From: Wilson , Claire (PLANNING ECOLOGIST) <ClaireWilson3@barnsley.gov.uk>
Sent: 02 August 2024 10:02
To: Craig Woolmer
Cc: Richard Mowat; Bennett , Laura (SPATIAL PLANNING PROJECT MANAGER); Isabel Syddall
Subject: RE: 2024/0122 Land at Hemingfield Road - Outline residential development - Additional Ecological Surveys Report

# LAND AT HEMINGFIELD ROAD

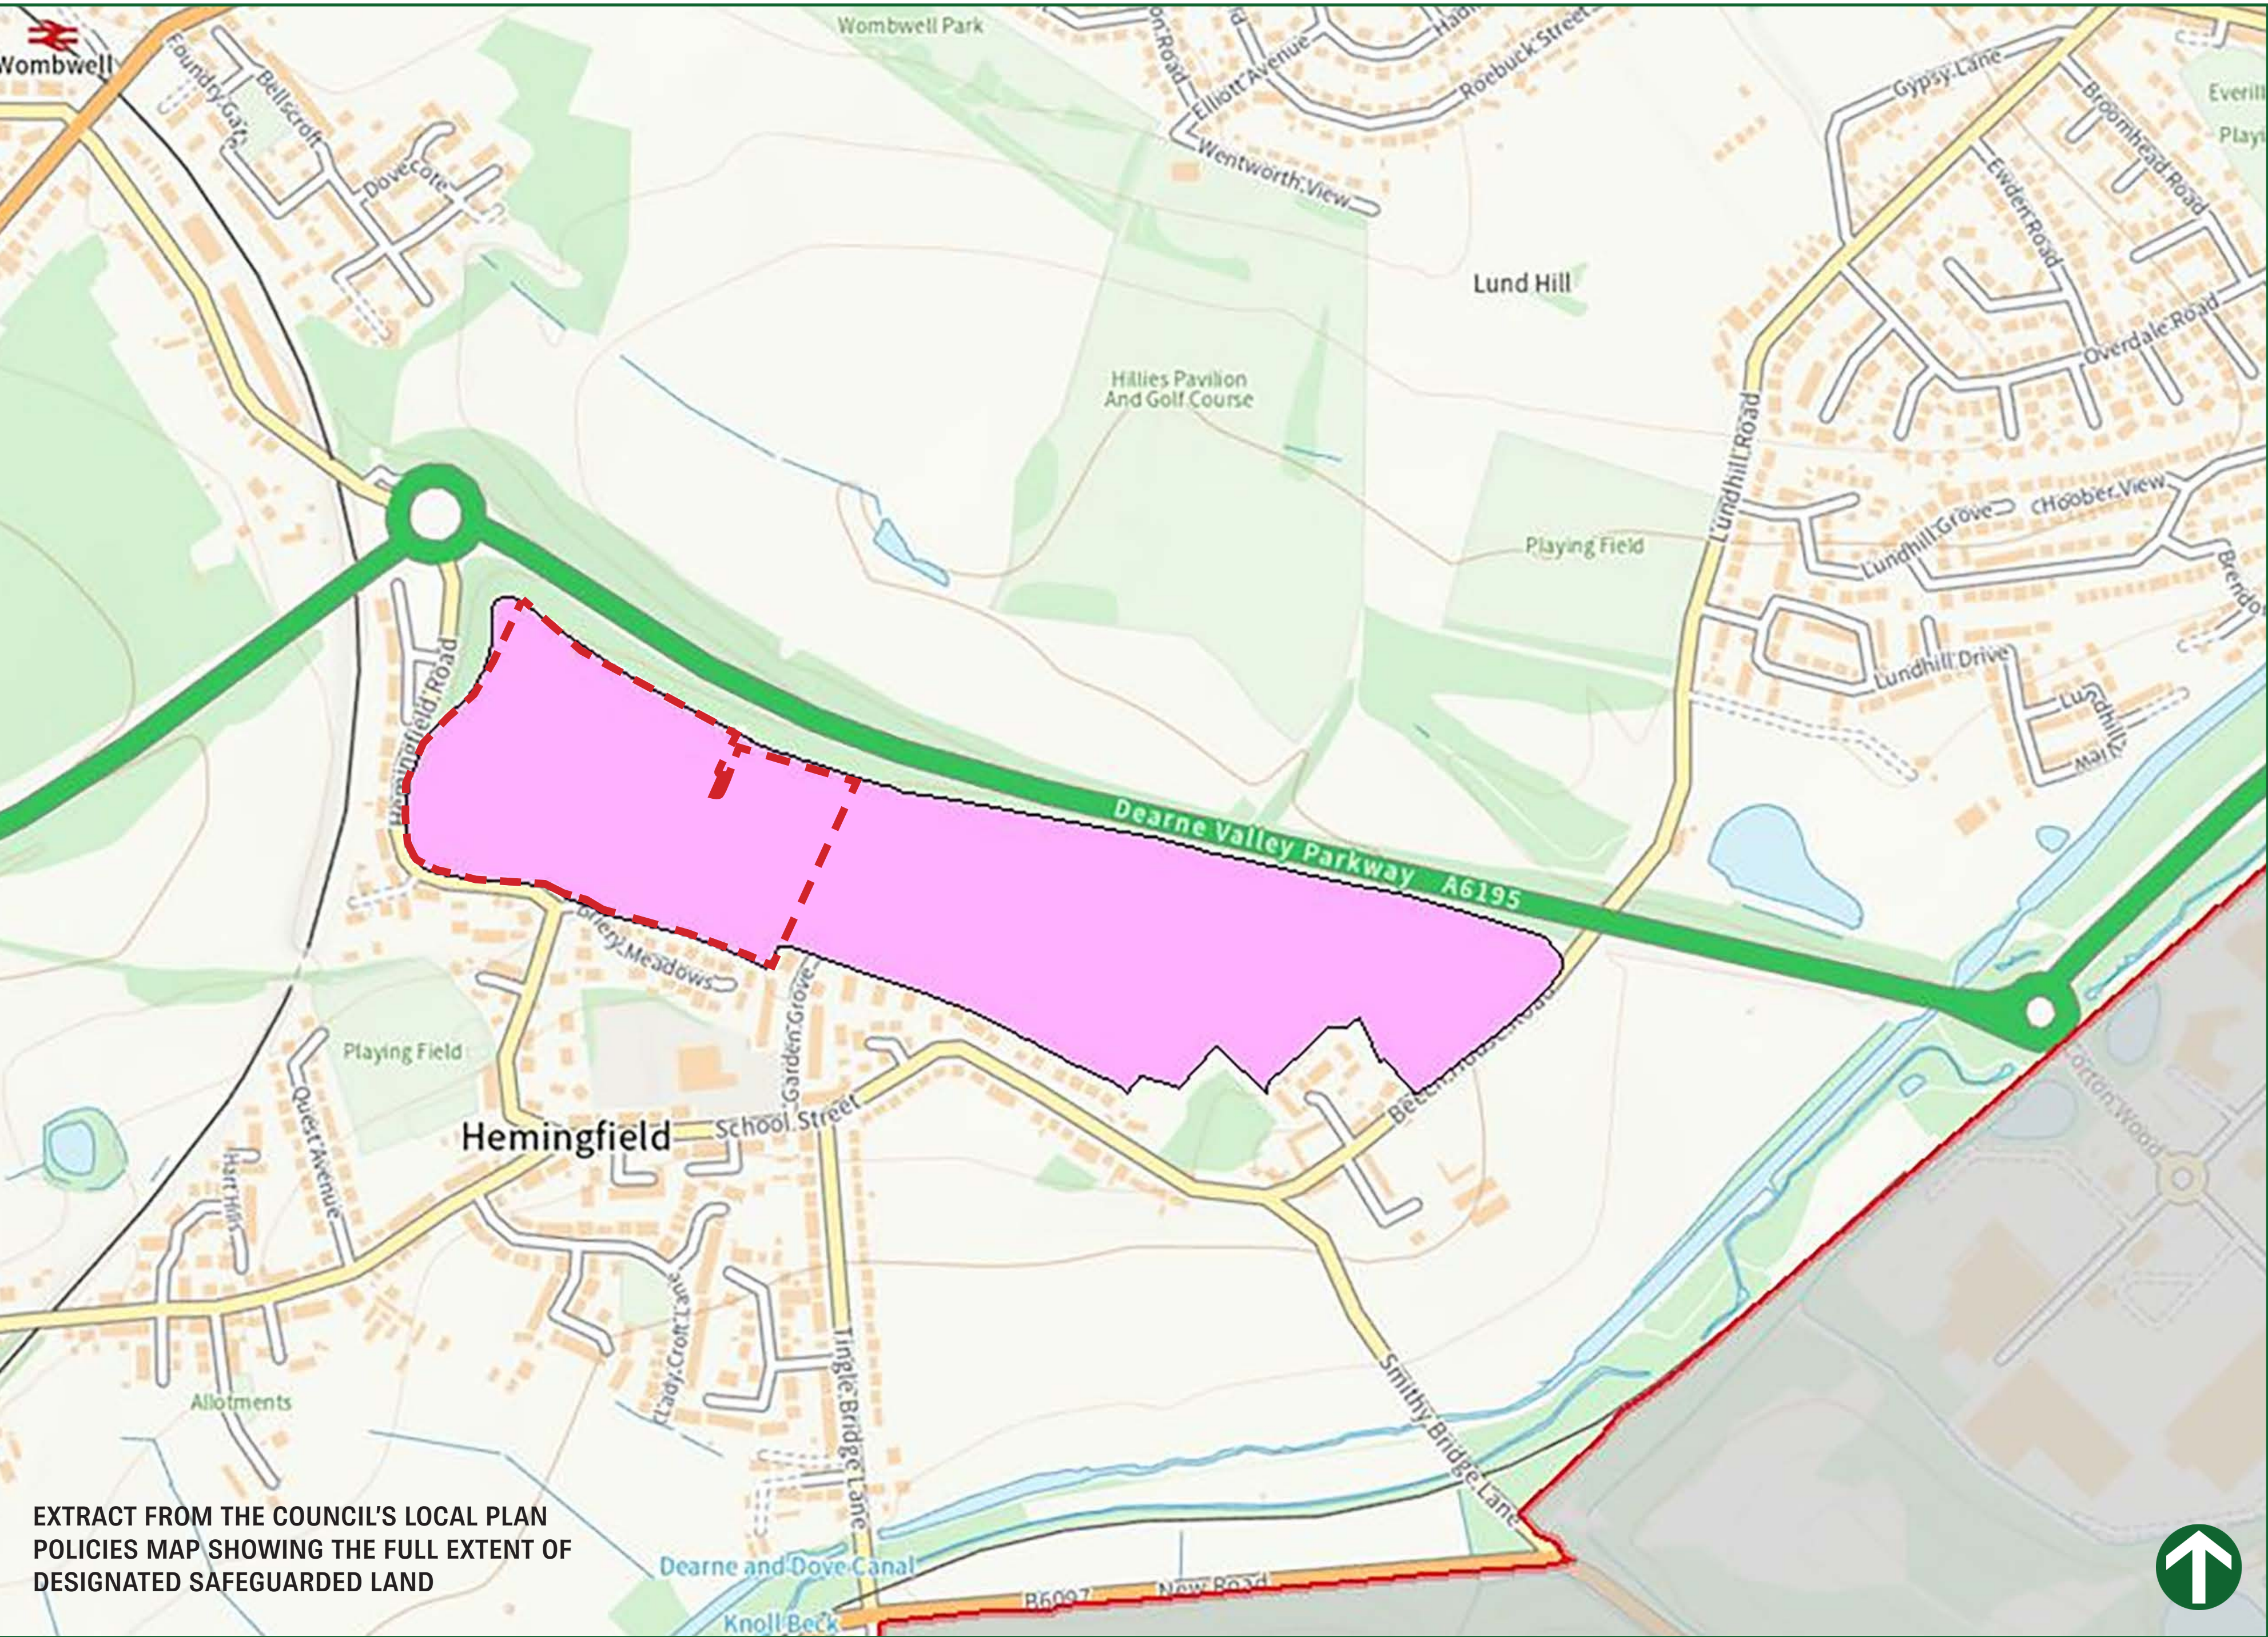
"I am content with the proposed habitats within the landscape masterplan and feel that they are appropriate and achievable. My only comment would be that the traditional orchard should be located in the north western corner of the site away from Hemmingfield road and closer to the woodland on the sites northern boundary."

The landscape masterplan has been submitted as an illustrative plan. Our application is seeking outline planning permission and landscape remains a reserved matter. This would therefore be dealt with at the stage that an application for the approval of reserved matters is considered. On this basis, it isn't our intention to change the masterplan at this stage.
